Lanktree Land Surveying, Inc.
25510 74th Avenue South
Kent, WA 98032
(253) 653-6423
www.lanktreelandsurveying.com

RE: MI Project No. SUB22-007, 8247 E Mercer Way

Response for NOTICE of INCOMPLETE APP (Letter Dated October 17th, 2022 – Andrew Leon)

DWN. BY	BGM	DATE	09/23/22	JOB NO.	5533
CHKD. BY	JSK/TSL	SCALE	1"=20'	SHEET	2 OF 2

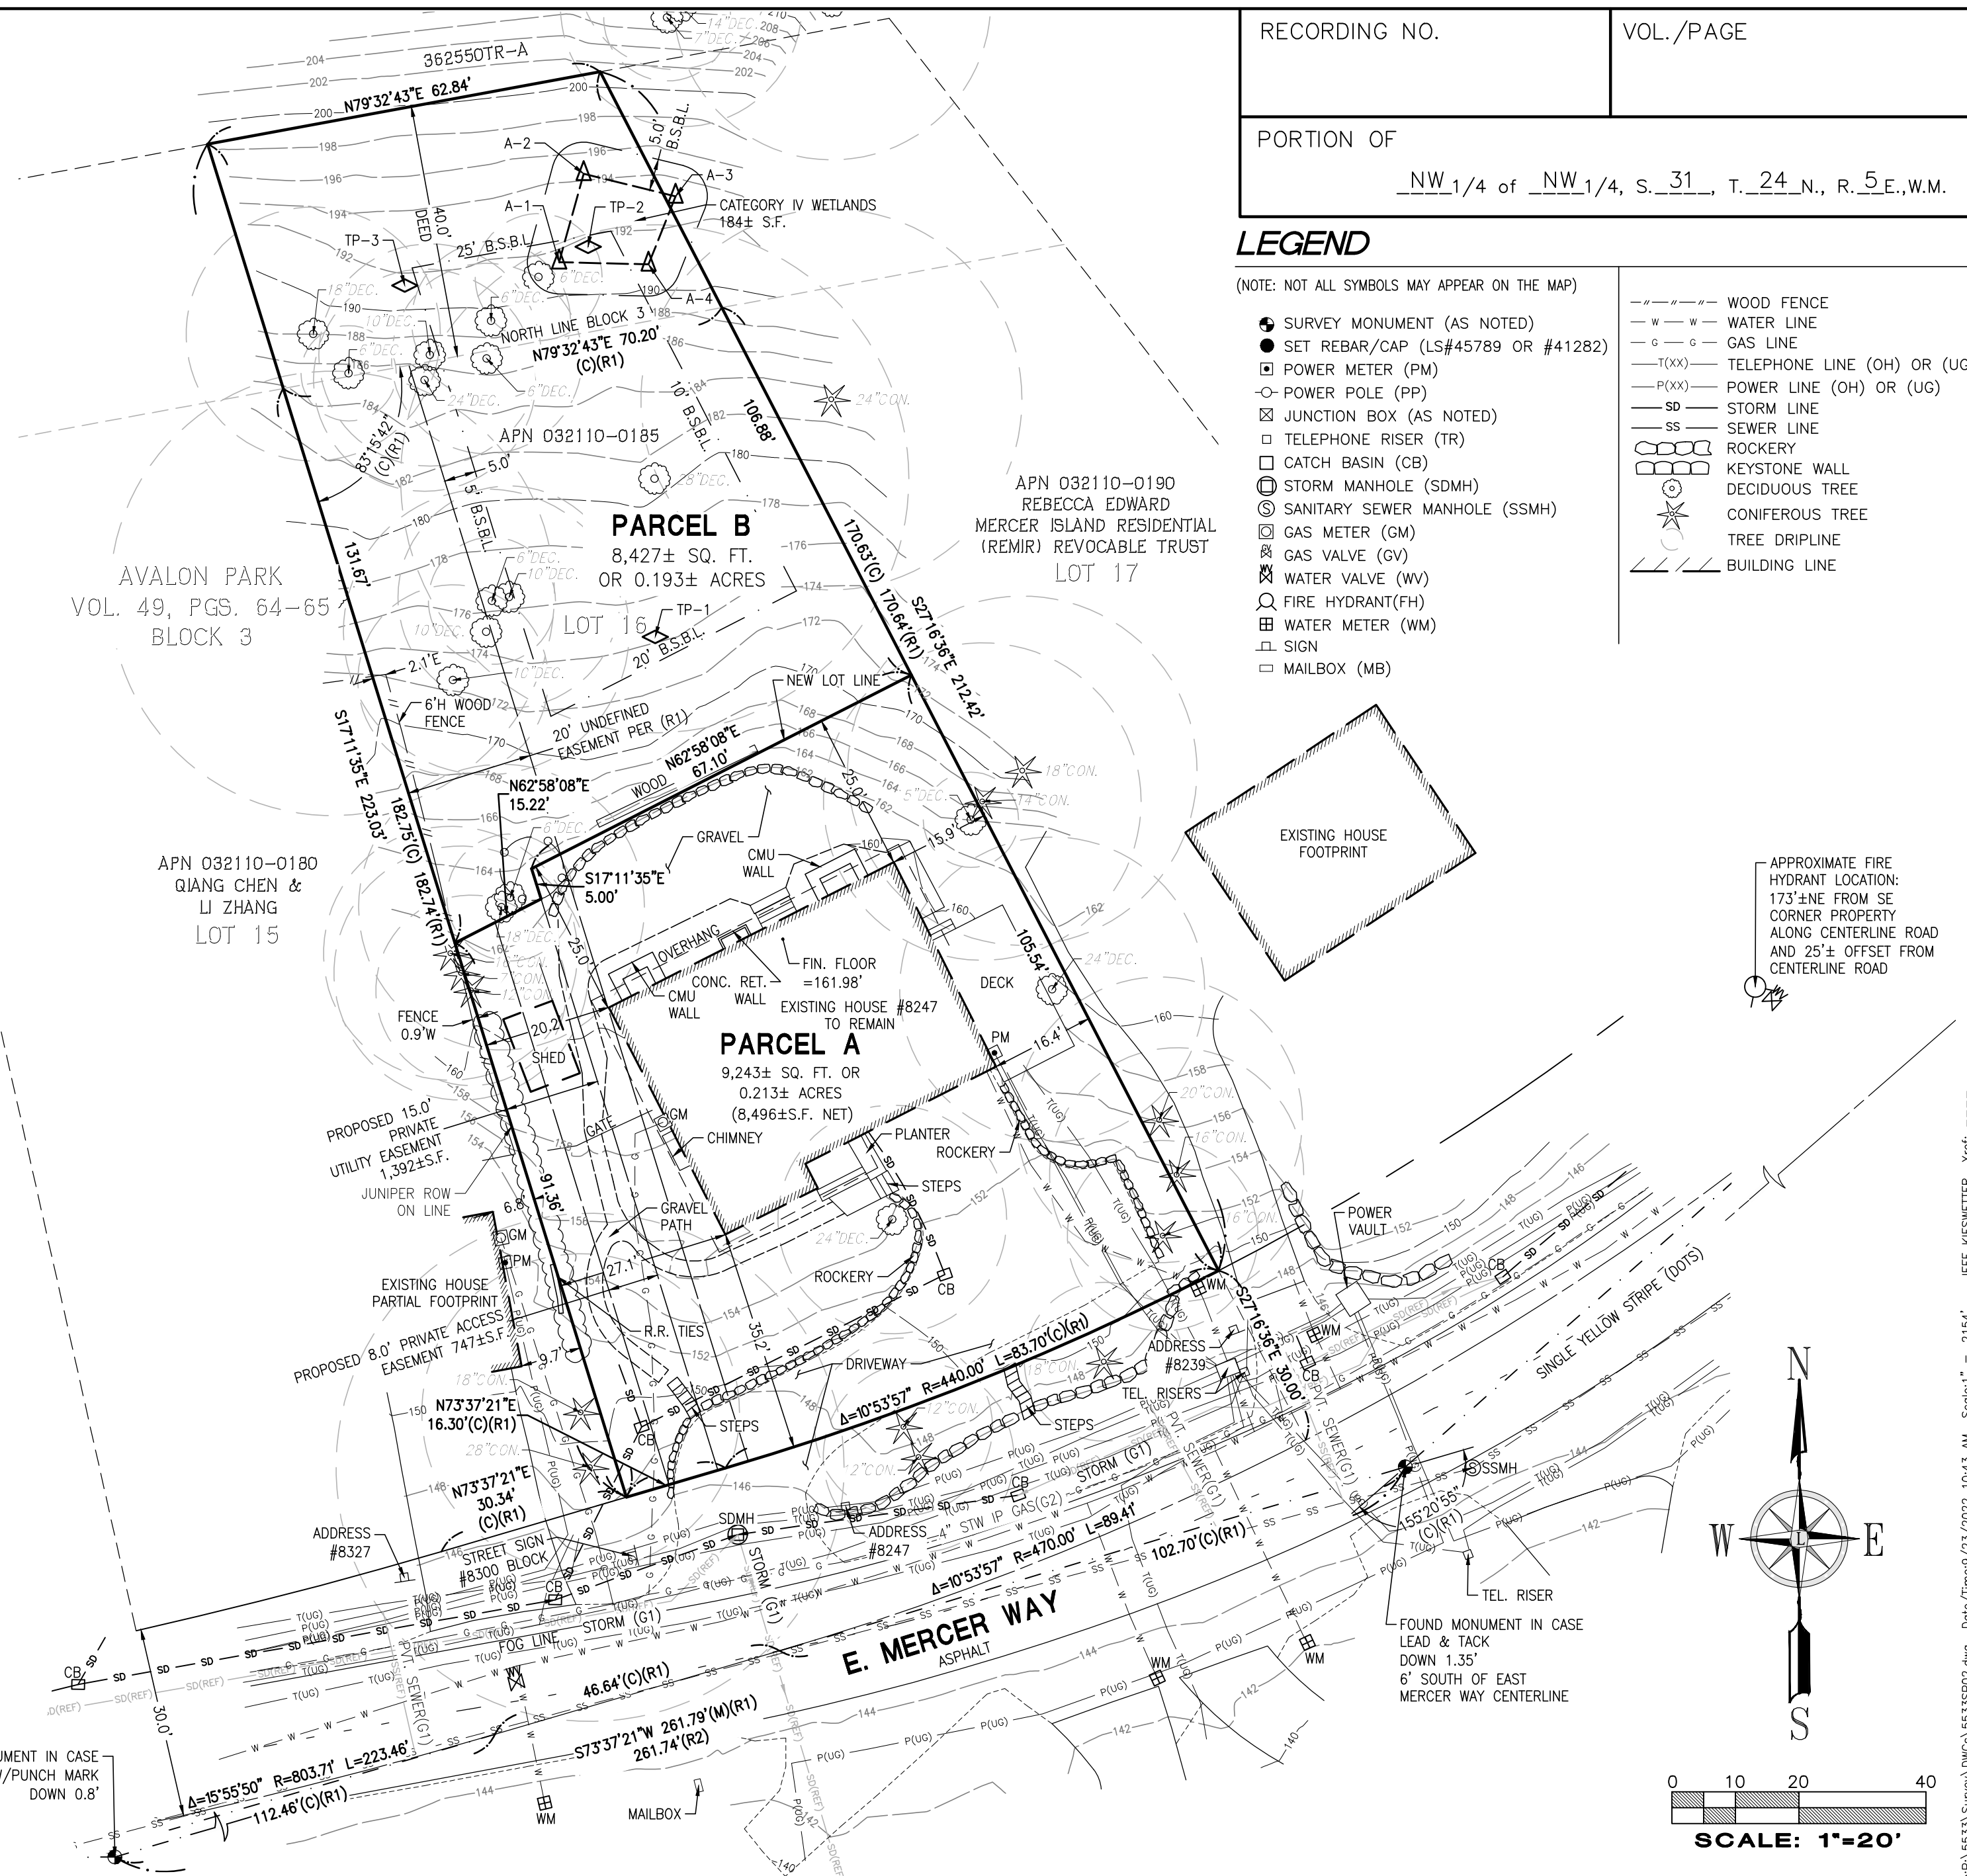
Comment 3. Please show building pads on the plans that are consistent with the standards listed in MICC 19.09.090. Please note that the building pads must be located outside of critical areas and critical area buffers. Building pads must also be located to minimize impacts to retained trees.

Response: Proposed building pads added to Short Plat drawings. Included in resubmittal upload.
